City of Albuquerque Stormwater Construction Site Inspection Report

ESC File No.	C18E075	Project Name:	Sevano Place Subdivision		
NPDES Id. No.	NMR10039R/NMR10039X/N MR1003B0	Location:	6300 Alameda Blvd. NE		
12/28/2021	Owner	owner & Contractor			
Operator	Sevano, LLC.	Stillbrooke Homes			
Contact name & title	Shakeel Rizvi	Chris Kelsey			
e-mail	shaky1424@yahoo.com	ckelsey@stillbrooke.com			
Contact Phone #	505-315-6563	505-858-1800			
COA Inspector	Doug Hughes	Start/End Time:	1pm		
Construction Phase:	infrastructure				
Type of Inspection:		Storm Event	Past Storm Event >0.25"	311/Complaint	Follow Up
Weather at time of inspection?		Cloudy	Temperature: ~		47
Estimated date of last storm 0.25" or greater		10/1/2021

SHEET:
6

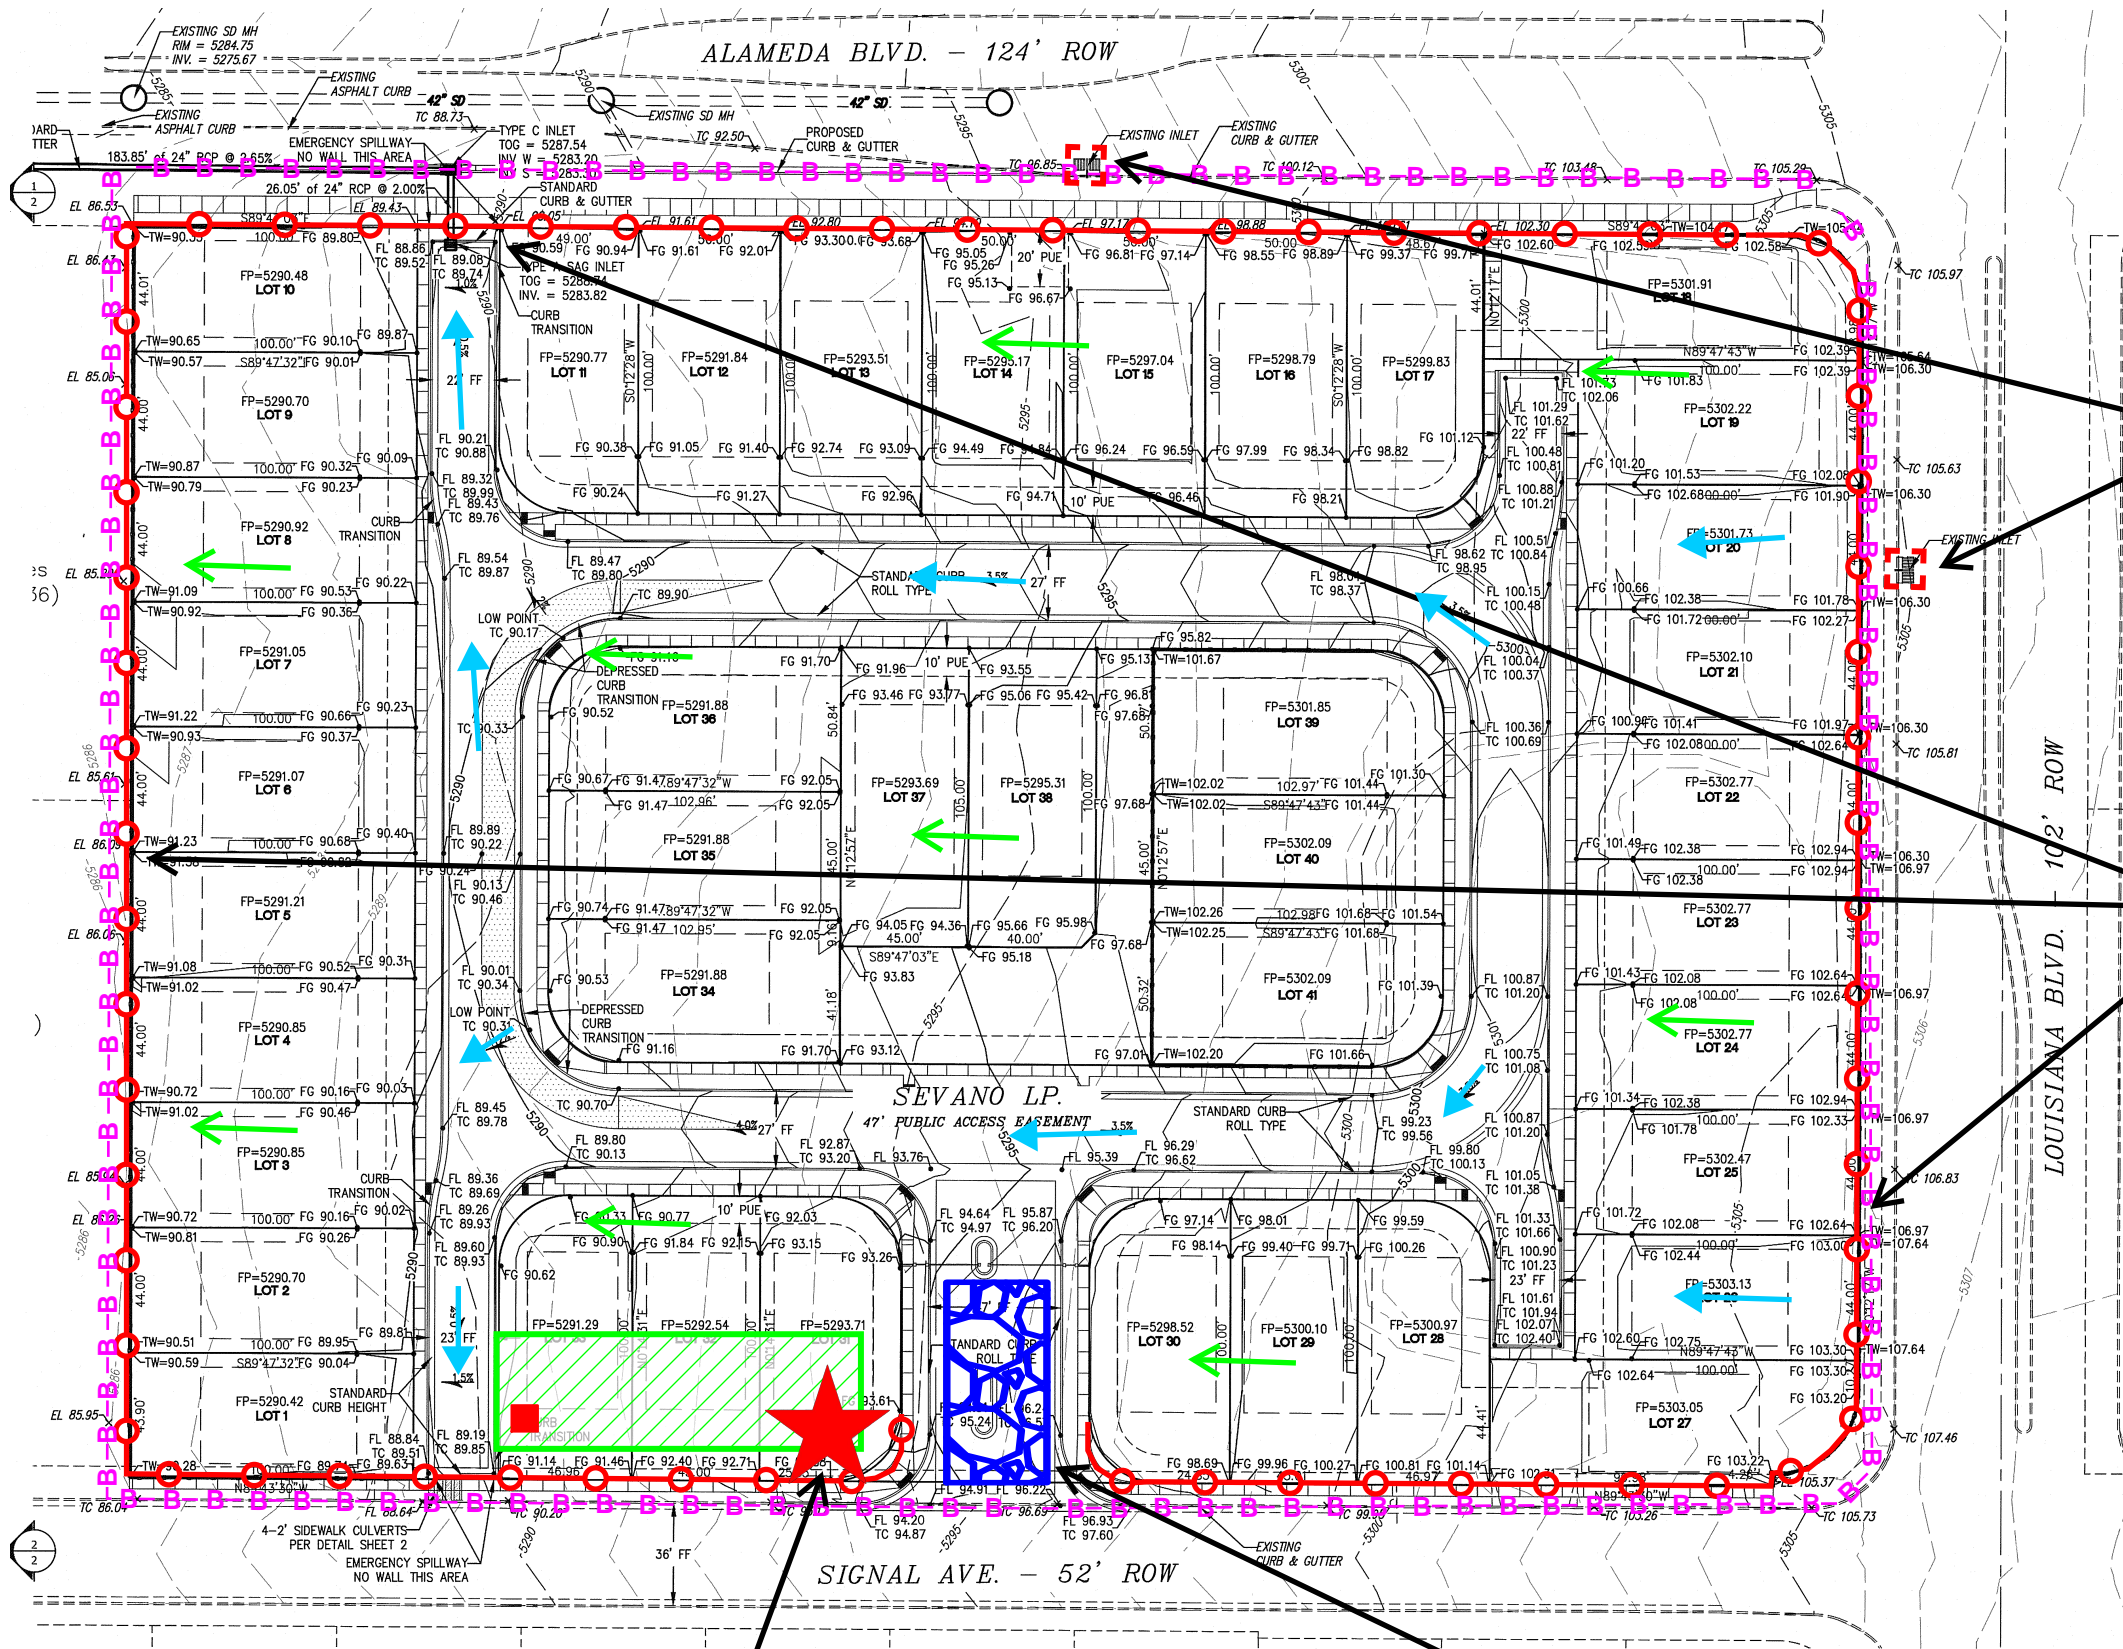
Item Number	Deficiency/ Corrective Action				
1	SWPPP map should not only identify the lots sold to Stillbrooke but also the finished occupied houses (3 or 4 now). Stillbrook's NOI (NMR1003UE) still missing from SWPPP				
2	Concrete, paint, and stucco washout still on the ground. Provide more washouts containers and pickup existing washout..
